Trevor Pearce
24 Rogers Avenue,
Haberfield 2045

Re: SSI 6307

I write to submit in relation to the Environmental Impact Statement for the WestConnex M4 East project. I am opposed to both the M4 East project and all other proposed stages of WestConnex. I request a response to my concerns outlined in this submission. (20151030 SL Final Part A)

Figure 2.2 Overview of construction footprint and construction ancillary facilities

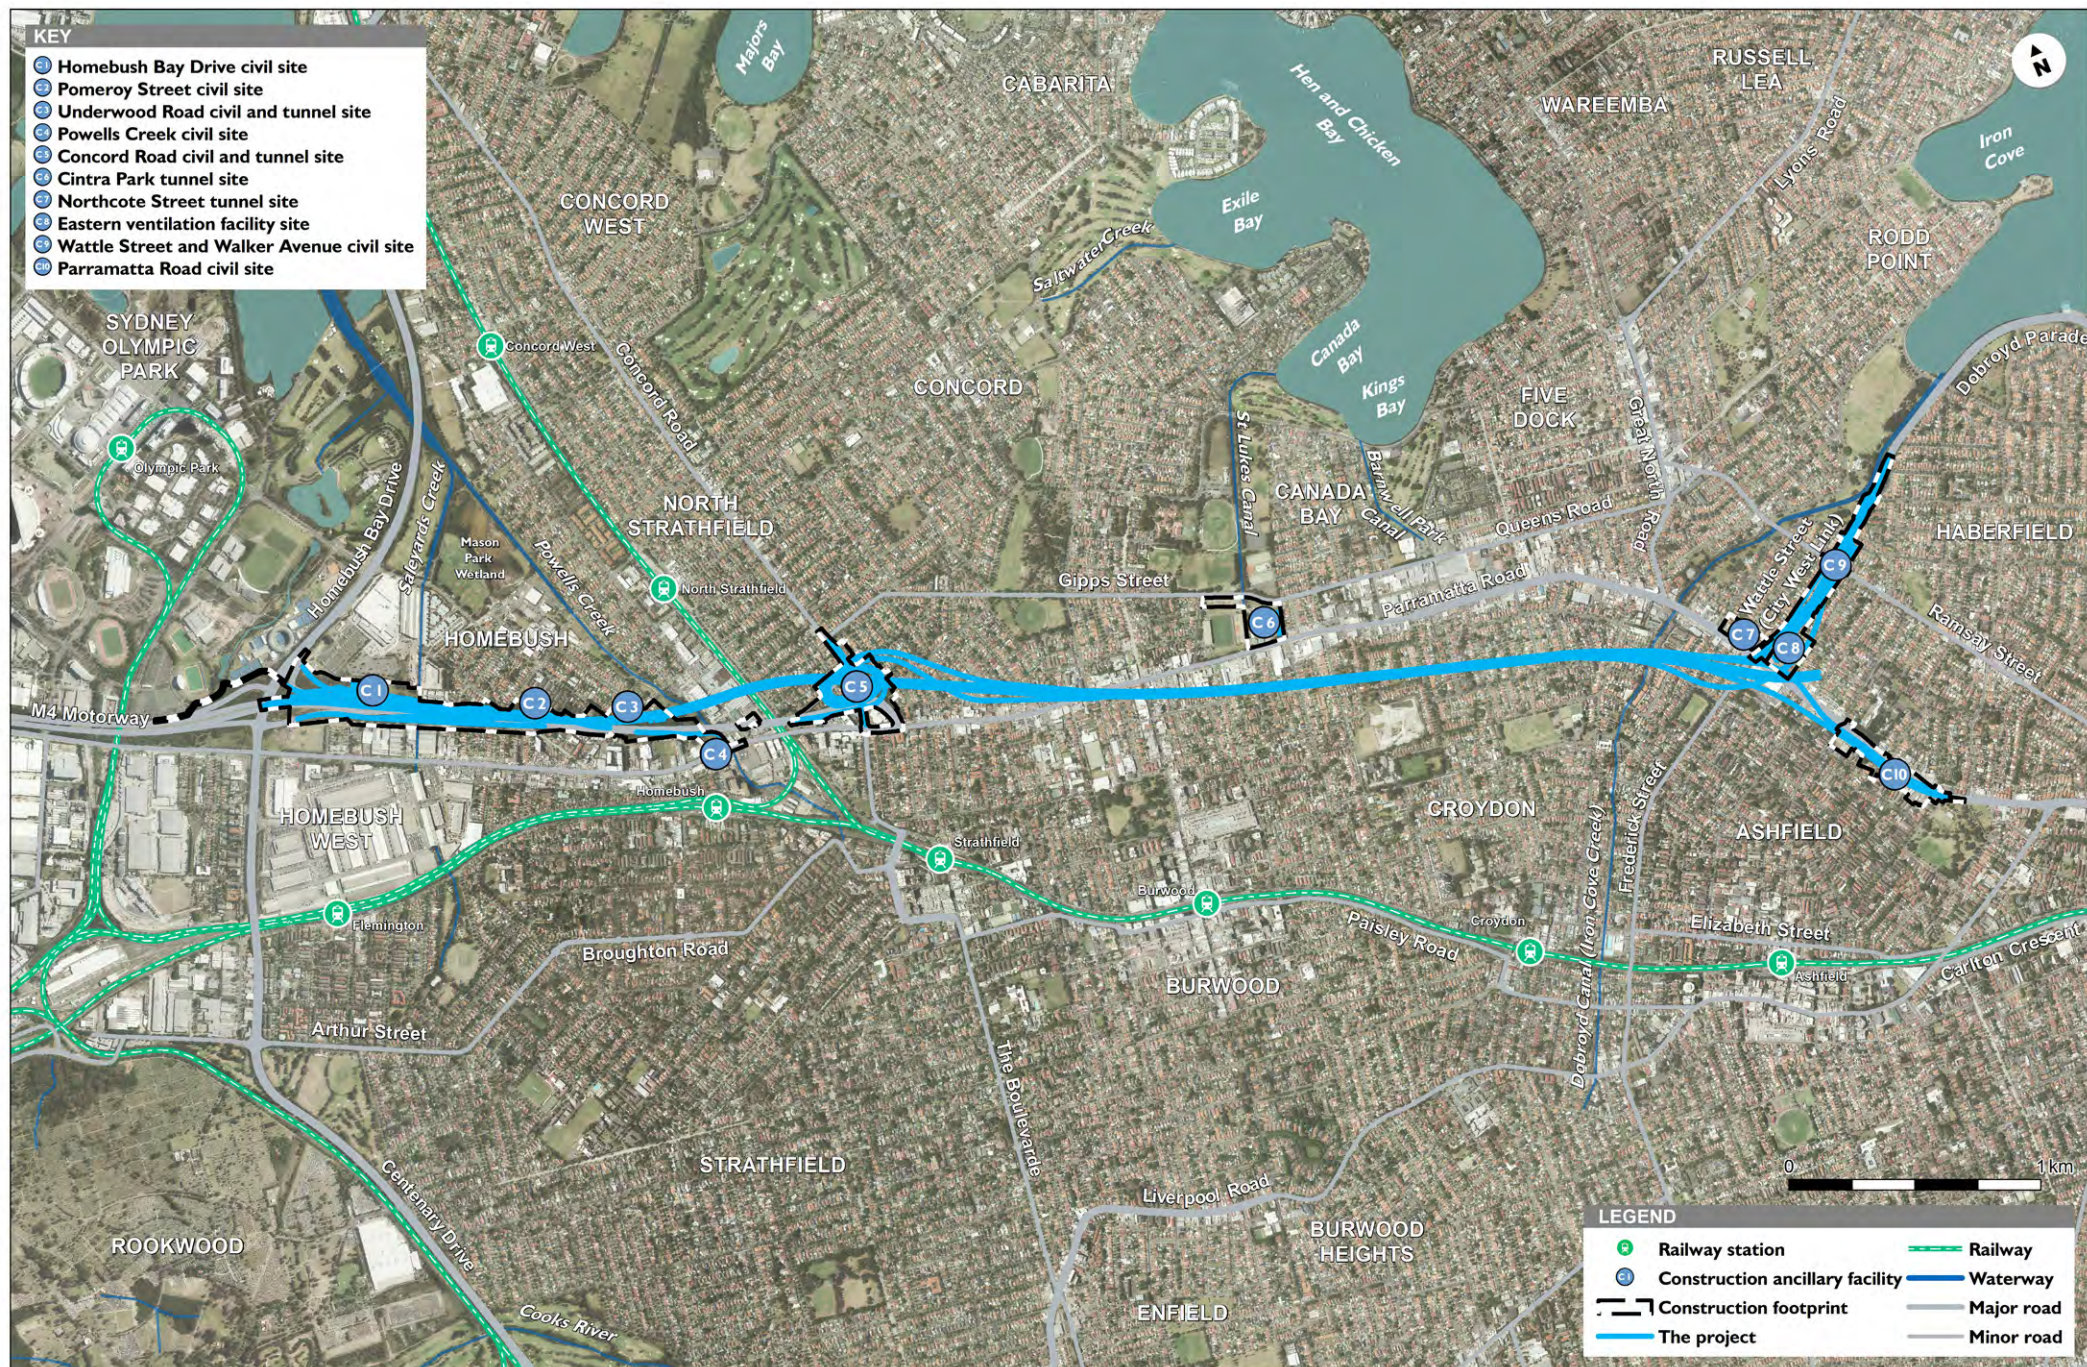
But I have found no specific mention of construction impacts on the neighborhood around Parramatta Rd, between Northcote St and Wattle St, Haberfield. Only that this residential and commercial neighborhood is identified as the 4th area to be impacted and is marked up as the C7 Northcote Tunnel site (Figure 2.2 Overview of construction footprint and construction ancillary facilities, page 13, Volume 2E).
